## Engineers Comments Regarding Surface Water Drainage

| <b>Application Reference:</b>   | A/44/26/PL                                                                                                                                                                                                  | <b>Reviewer Reference:</b> | ADC/EXT5/AF |
| <b>Site Name:</b>               | Former Shrublands Nursery Roundstone Nursery Angmering BN13 4AT                                                                                                                                             |                            |             |
| <b>Application Description:</b> | Retention of 40 No dwellings (after demolition of previous buildings) and associated operations (resubmission following A/115/25/PL). This application is in CIL Zone 2 and is CIL Liable as new dwellings. |                            |             |

Client	SIGMA HOMES		
Scale	1:200 @A1	Date	JUL 2025
Drawn	AK	Checked	BO
Job No	21-254	Drawing No	21-254-702
Rev	E	Designed	AK
		Approved	BAC

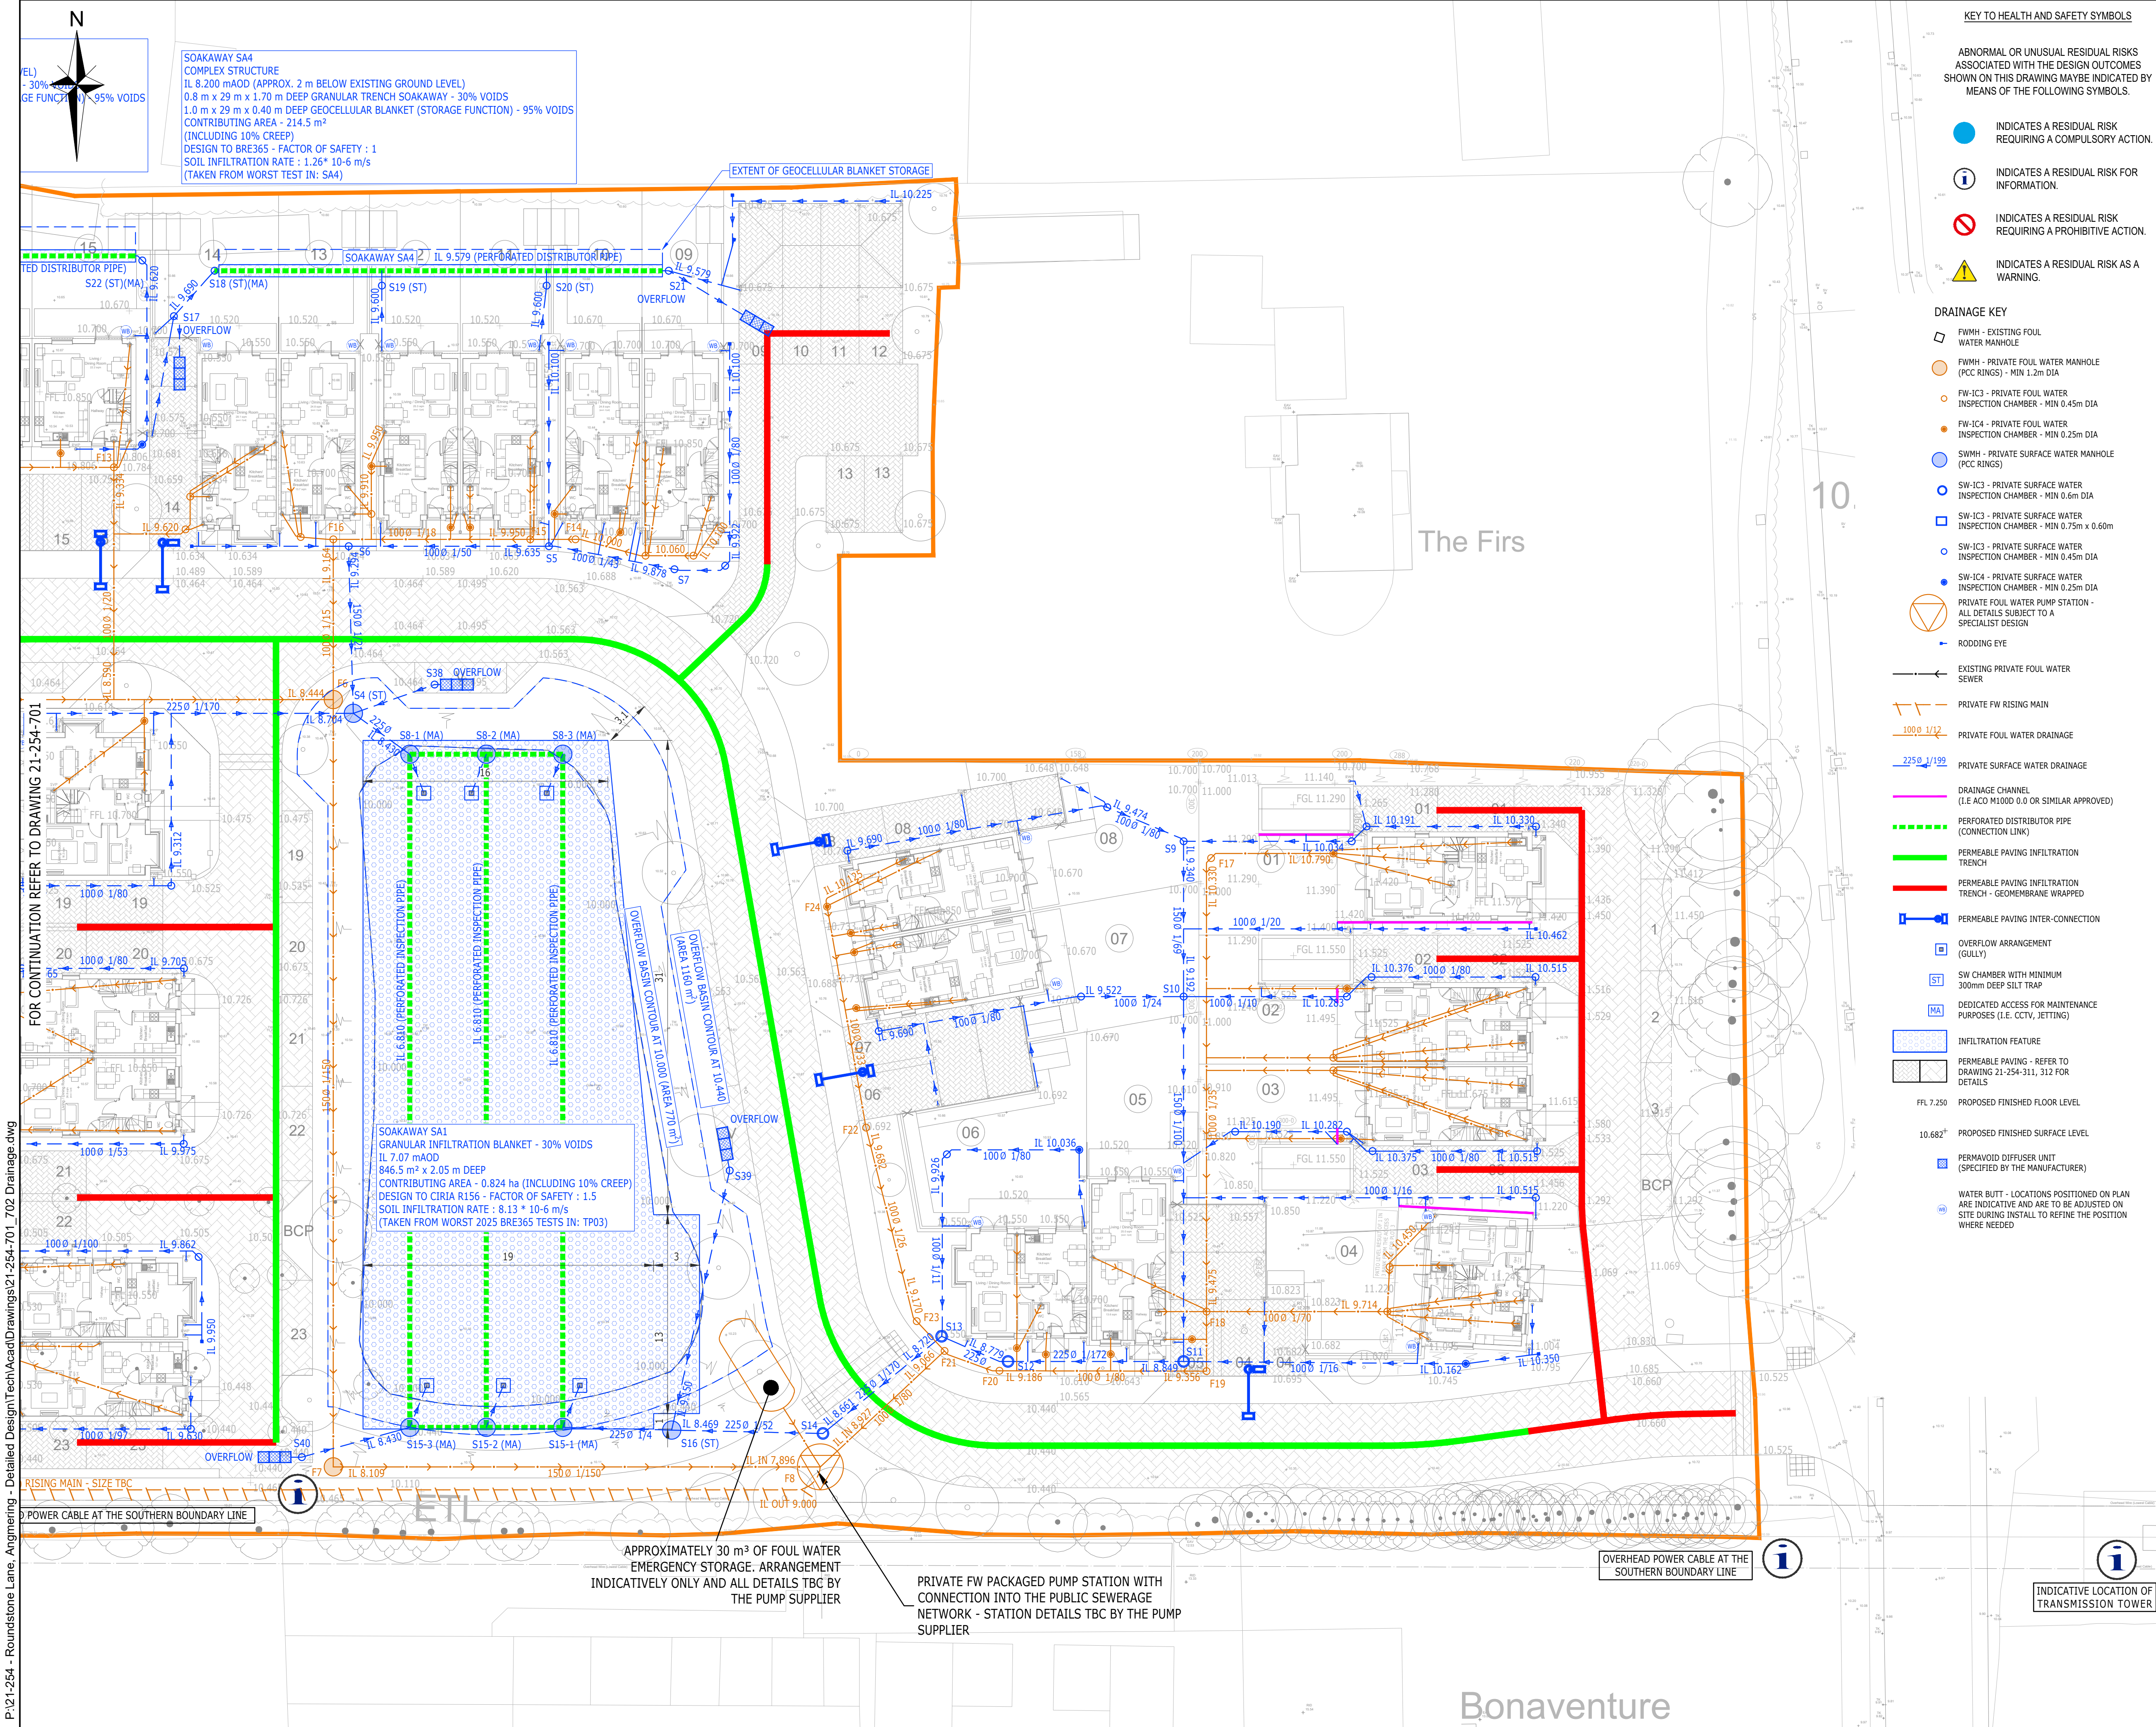
- 1.1. Water butts are noted in the Drainage Statement report to be retrofit at the existing properties but are not currently shown on all properties on the revised drainage layout plan 702E. Plots 1, 2 and 3 appear to have been omitted. The product specification should also be provided as a technical design.

1.7. Further information is required for the water butts as a technical design.
